DEVELOPMENT REVIEW BOARD TRANSPORTATION DEVELOPMENT Standard Comment Sheet

DRB-1002720

RE :North Albuquerque Acres,

DESCRIPTION OF REQUEST: Sketch Plat approval, Ventura Estates

# SKETCH PLAT

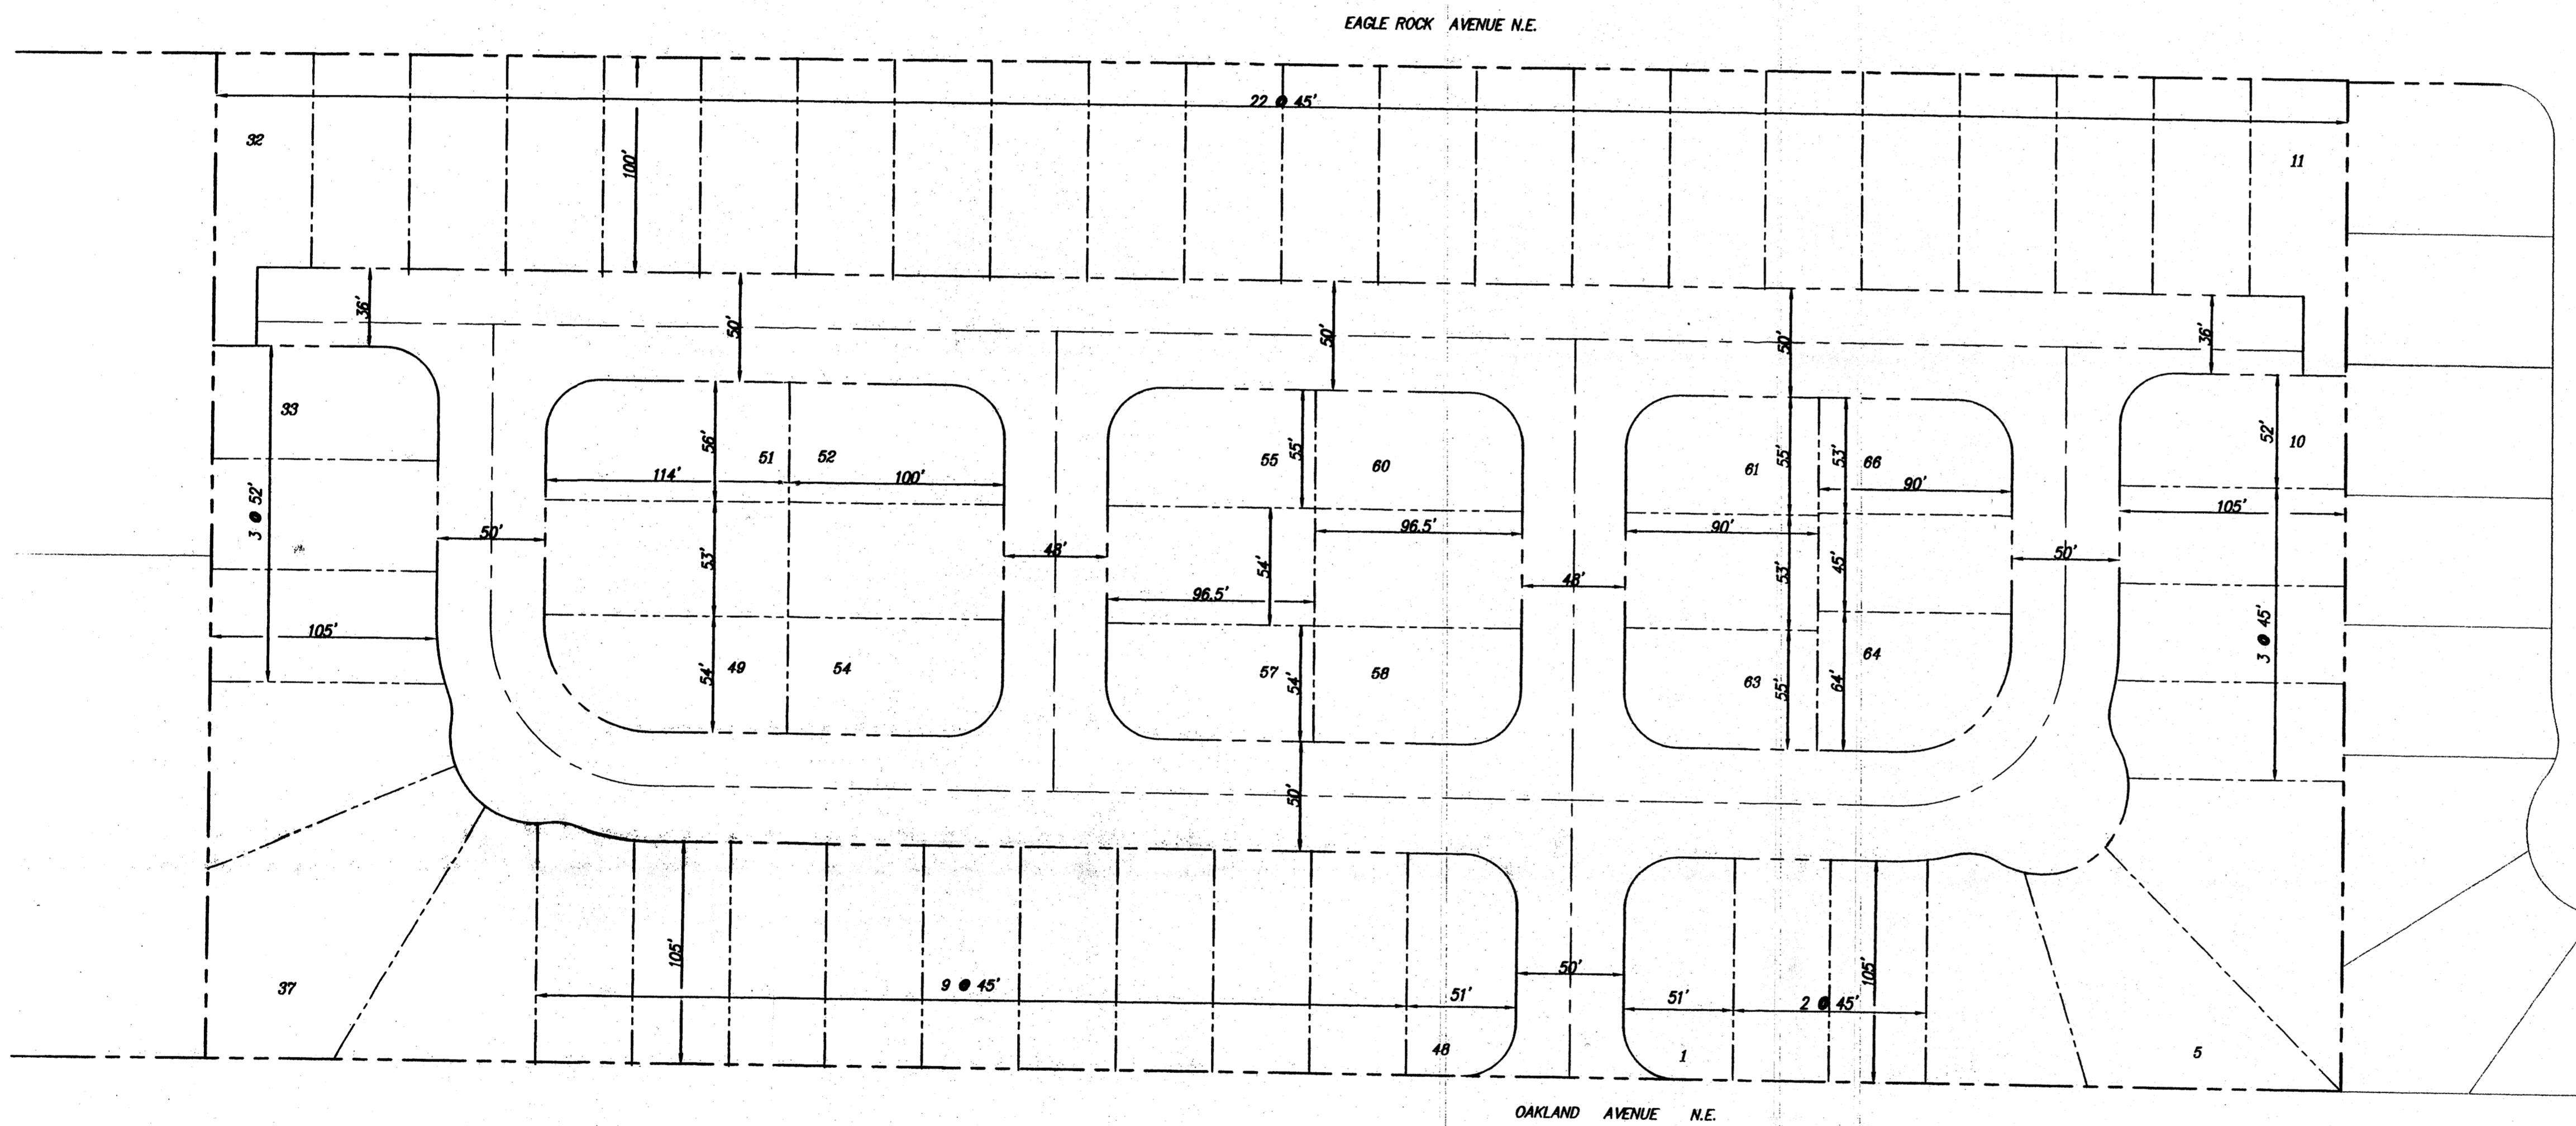
No.	Comment
<input type="checkbox"/>	The standard street improvements are required on an infrastructure list.
<input type="checkbox"/>	The streets need to meet the requirements of the DPM.
<input type="checkbox"/>	A traffic distribution layout is needed.
<input type="checkbox"/>	A connecting street to Eagle Rock is needed.

The R-D zone requires 2,400 square feet of open space for each dwelling unit. With submittal of the Preliminary Plat/Site Development Plan, provide an Open Space Calculation Table showing the lot number, lot size, building & driveway area, provided open space, remaining open space requirement (this table can be separate from the plat itself). Provide a dimensioned Typical Lot Plan, which shows a typical lot with the building footprint and driveway (this should be on the Site Development Plan rather than the plat). Include one of the following notes on the Preliminary and Final Plats indicating how the total remaining open space requirement will be met:

An approved drainage report is required for Preliminary Plat approval.
 An approved infrastructure list is required for Preliminary Plat approval.
 Development projects with land area of 1 acres, or more, are required to file a Notice of Intent (NOI) with the US Environmental Protection Agency for storm water discharge during construction.

This property lies within the North Albuquerque Acres Sector Plan boundaries. Page 45 of the plan states the requirements for RD zoning.

The application for this subdivision will not be heard until the required Notice of Decision on the zone change is submitted.
